Our ref: DOC21/992644  
Senders ref: SSD-17424905

**Subject: EES comments on Environmental Impact Statement for Pymble Ladies College – Grey House Precinct – SSD-17424905 – 20 Avon Road Pymble**

**Subject: EES comments on Environmental Impact Statement for Pymble Ladies College – Grey House Precinct – SSD-17424905 – 20 Avon Road Pymble**

Figure 2.1 Native vegetation cover within 1500m buffer around the site. Seedmap, 2021.

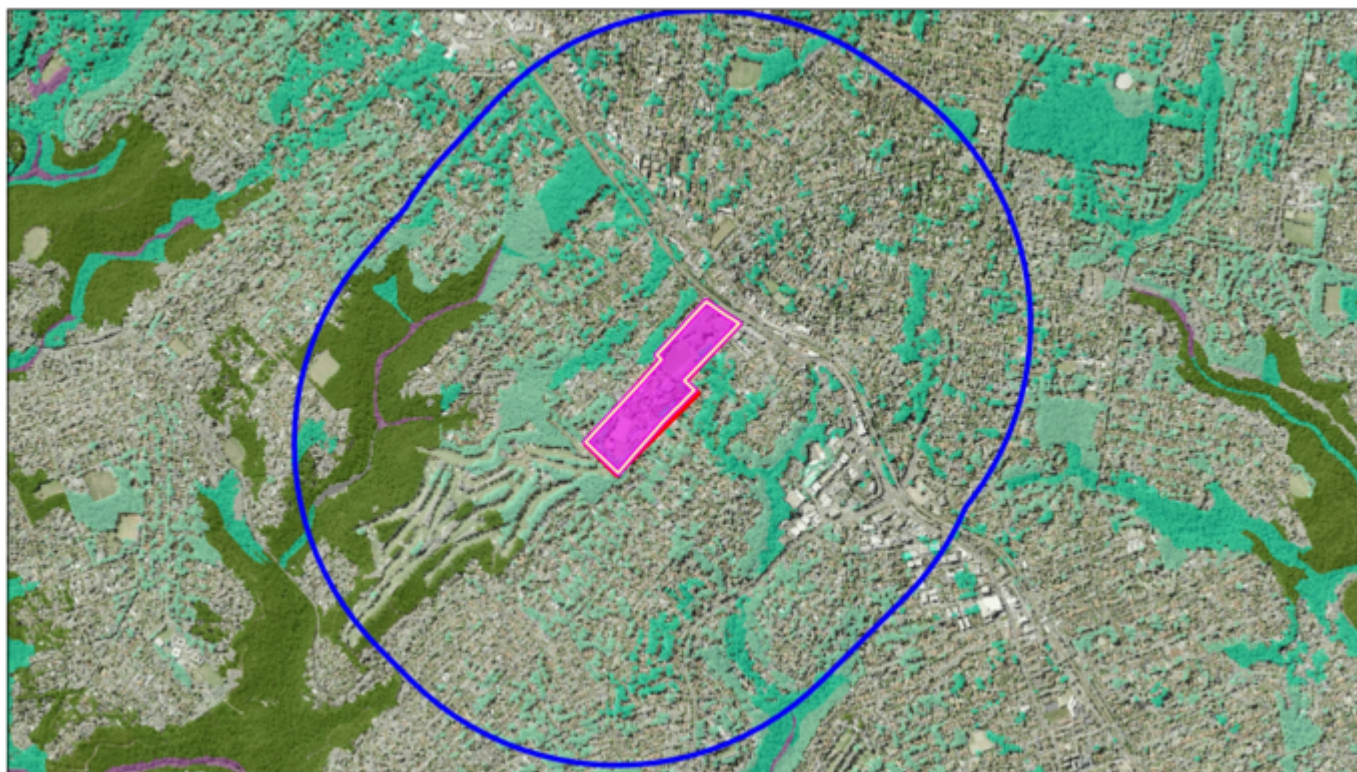
- It is not clear from Figure 2.1 what native vegetation has been included in the count of 25% cover as there's no legend to the map. RtS needs to clarify if both dark green and aqua vegetation been included and why has a map been provided with the vegetation marked as different colours.
